Your Ref: OWPC14532
Our Ref: R/64/17/PL 17-03-2017
Please ask for:
Mr D Easton

Demolition of 1 No. dwelling & erection of 4 No. dwellings. This application affects the character & appearance of the Station Road, East Preston Conservation Area.

St. Marys Close Hurst Road Rustington

Objections to the amended plans are as follows:

Drg No: 151117_SS-01 Rev: D

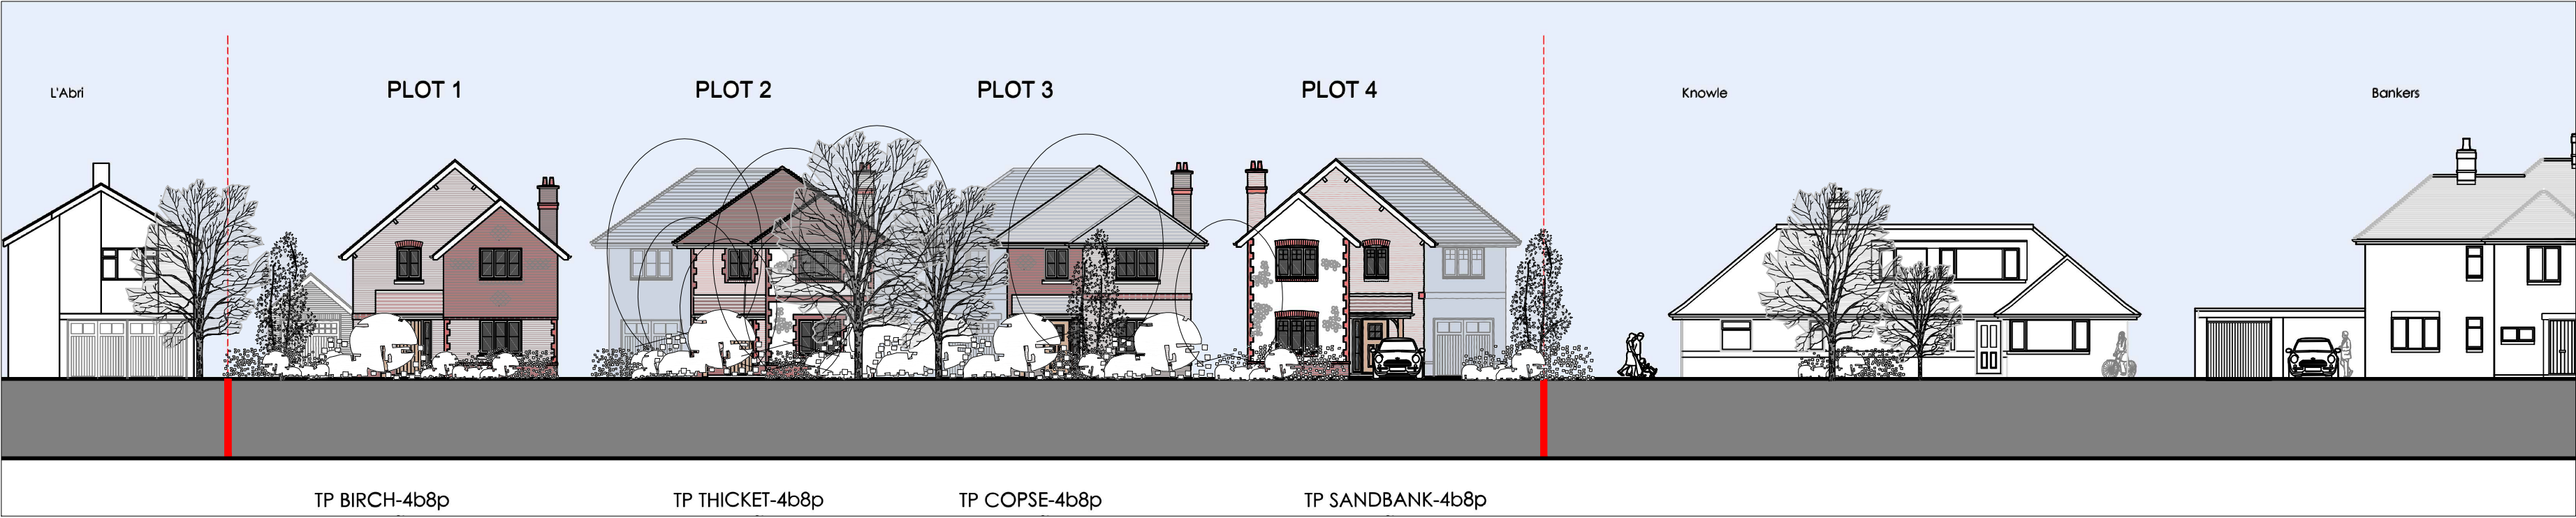
- 4) In the amended plan the 2 garage blocks have been moved behind the building line, which deals with one of my original objections. However, the house on plot 4 is now of a different design and includes an integral garage. This makes the house wider and 2 of the other houses have been shunted along to make room for it. This make the gaps between the houses smaller and it makes the whole site look even more overcrowded than it was before.*
